Response to Planning application from Hertfordshire County Council (T and CP GDP Order 2015)

District ref.	6/2021/2857/MAJ
HCC ref.	WH/10075/2021
HCC received:	6 December 2021
Area manager:	James Dale
Case officer:	Sarah Hearn

Location
Tewin Road, Welwyn Garden City, AL71BD

Change of use from former gasholder site and car dealership (Sui Generis) to industrial processes (E(g)(iii), general industrial (B2) and storage or distribution (B8) and erection of three new commercial units with associated access, servicing, landscaping and boundary treatments.

CLIENT	HBD								
SCALE	1:250	SIZE	A3	DRAWN BY	DW	CHECKED BY	KH	DATE	05.07.2021
PROJECT REF	21055		DWG NO	004(1)		REV	D

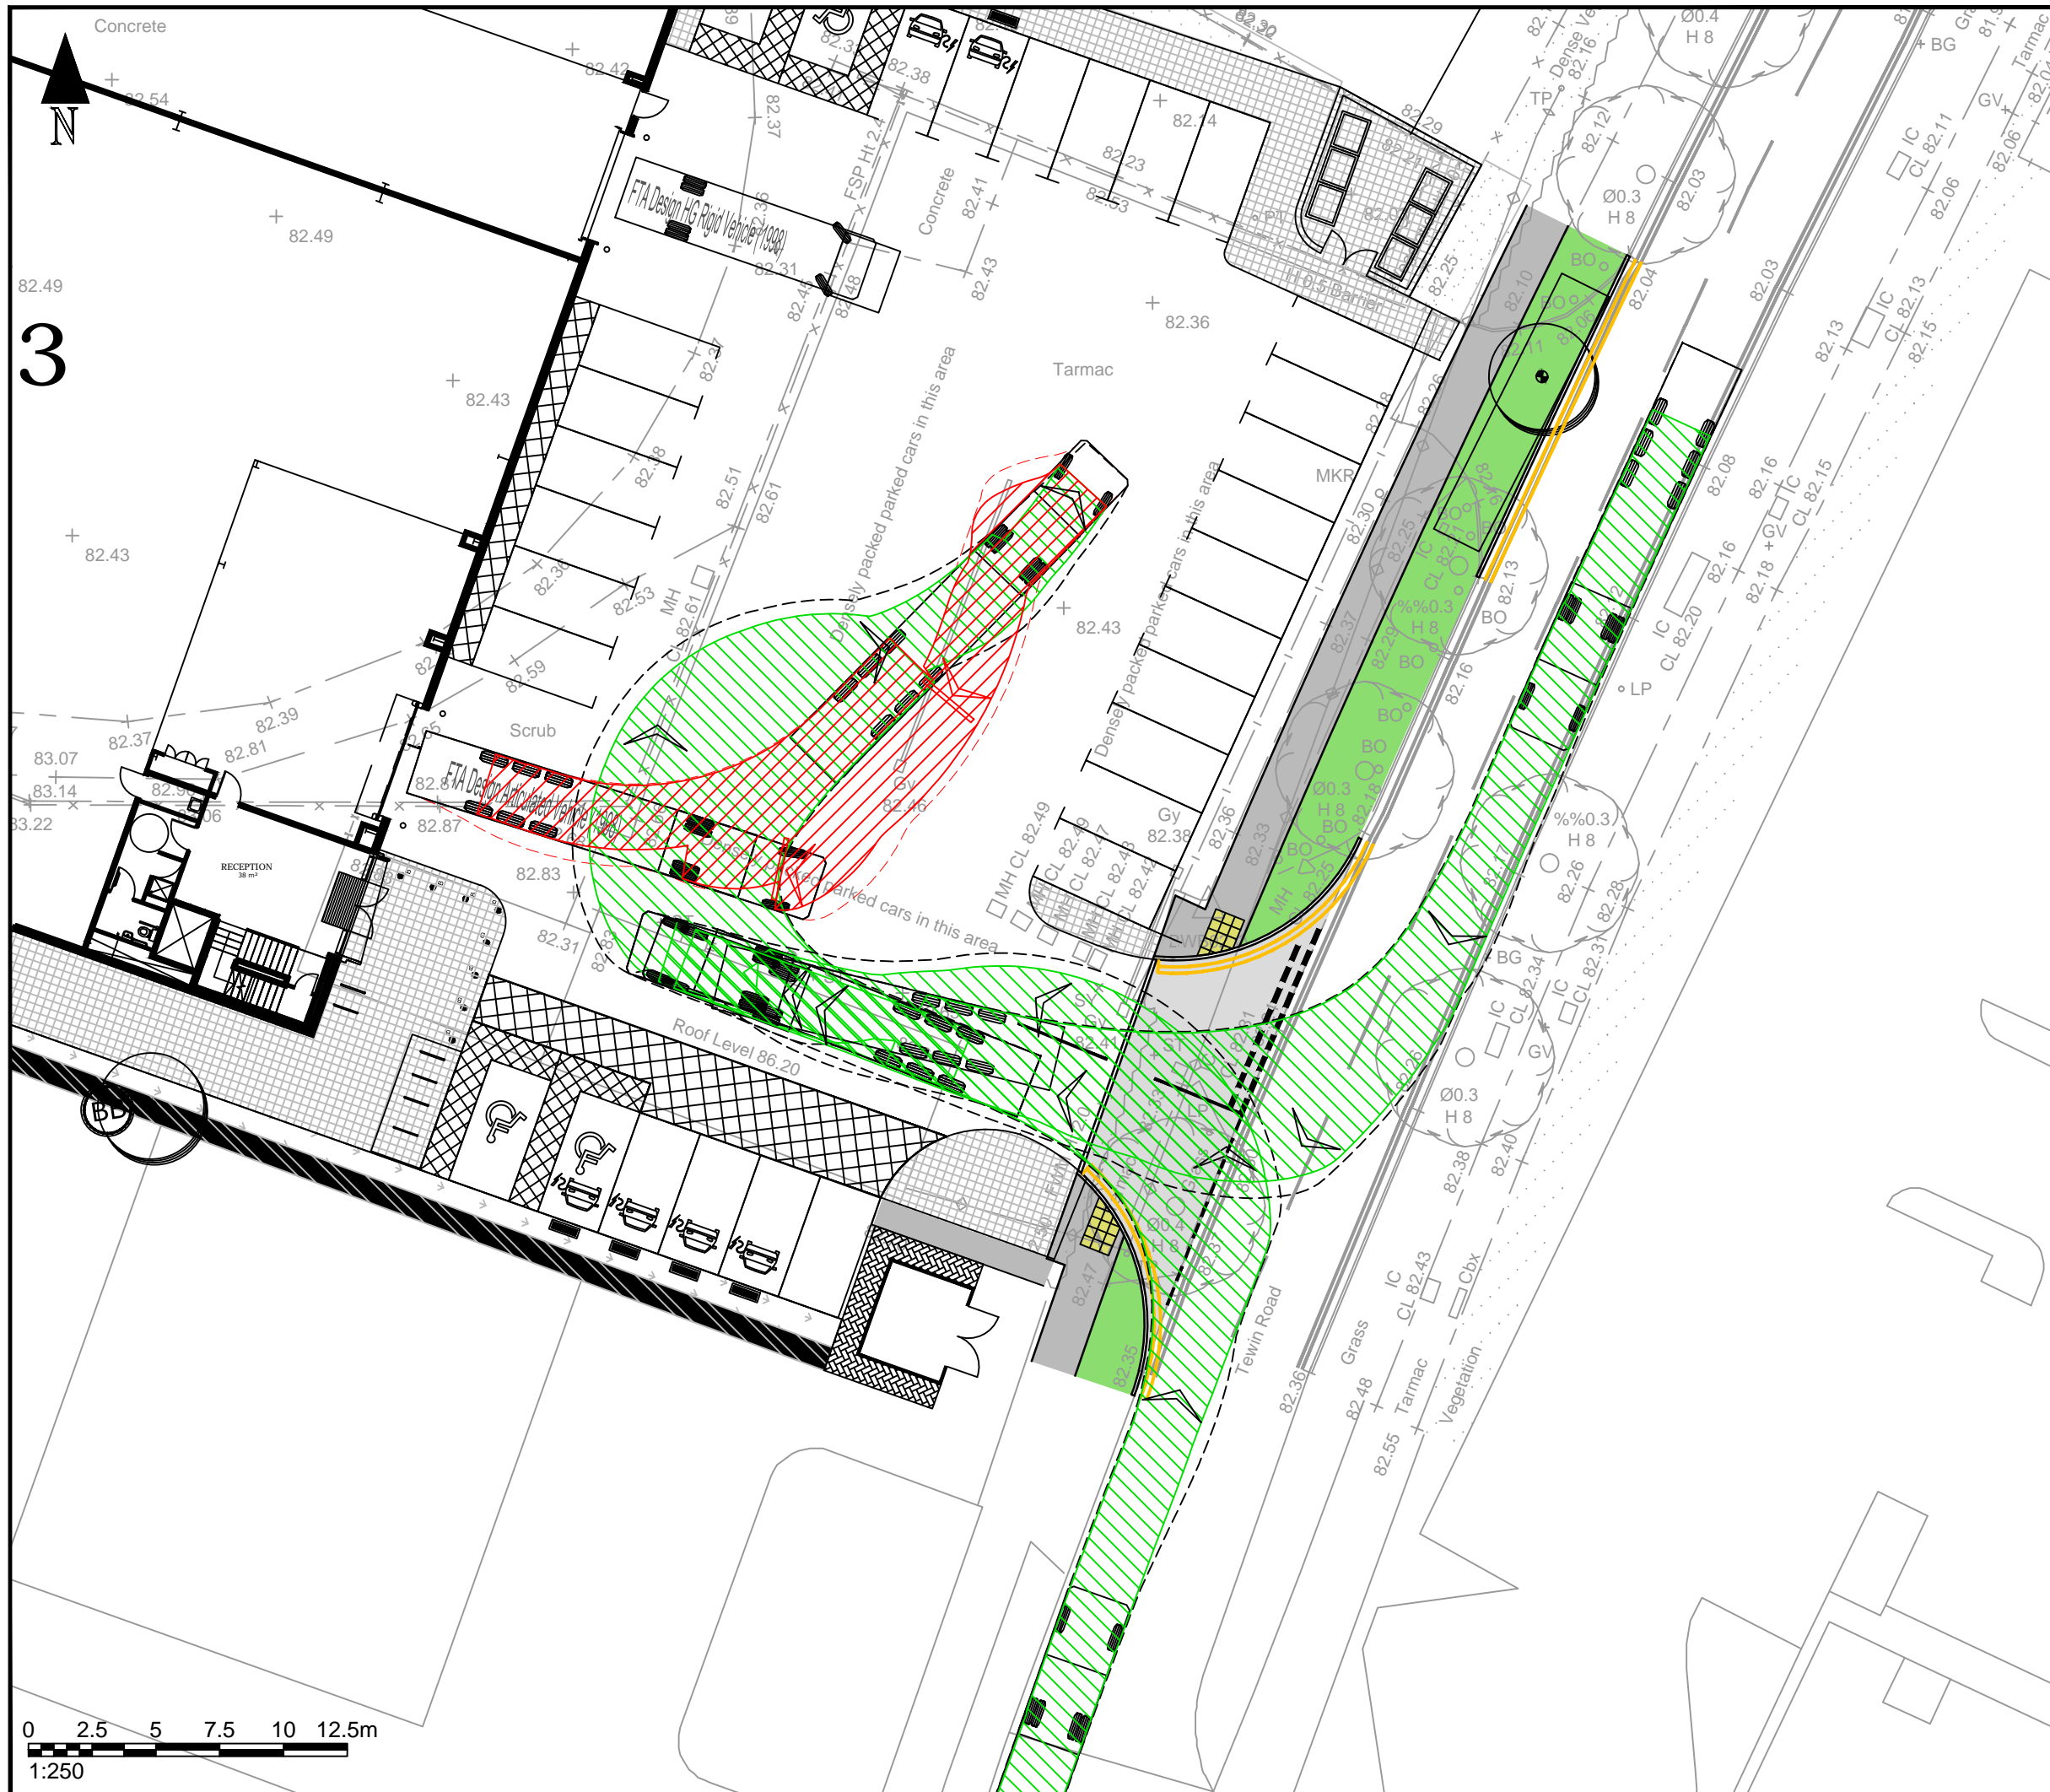
- 1) Prior to the first use of the development hereby permitted the vehicular accesses shall be completed and thereafter retained as shown on drawing numbers 003(1) B and 004(1) B in accordance with details/specifications to be submitted to and approved in writing by the Local Planning Authority in consultation with the highway authority. Prior to use appropriate arrangements shall be made for surface water to be intercepted and disposed of separately so that it does not discharge from or onto the

The submitted drawings show both vehicular accesses to measure c. 8.0m with an 8.0m kerb radii and c. 24.0 bellmouth. Swept path analysis drawings have been submitted illustrating that delivery and servicing vehicles can safely access the site. An assessment of how the widening the accesses will impact on the pedestrian environment has also been undertaken. Tactile pavings and dropped kerbs are proposed either side of each access and as previously highlighted in the pre-application advice, a c. 24.0m wide bellmouth is very wide. It is however noted that the pedestrian crossing points will be only c.10m in width. Whilst still relatively wide, the need for large vehicles to enter the site is accepted and a 10m crossing point for pedestrians is accepted.

Regarding visibility, it must be ensured that visibility of 2.4m x 43m is achievable in both directions from the proposed vehicular accesses. The two access plans include visibility splays and it is noted that there are existing street trees within the splays.

I have consulted Manual for Streets (paragraph 10.7.2) which advises that 'the impact of other obstacles, such as street trees and street lighting columns, should be assessed in terms of their impact on the overall envelope of visibility.' After assessing the street trees along the site frontage, I am satisfied that they will not fully obscure a whole vehicle or pedestrian and therefore the required visibility splays of 2.4m x 43m can be achieved from both accesses. These visibility splays must be retained at all times and this will be secured by way of condition should this application gain permission.
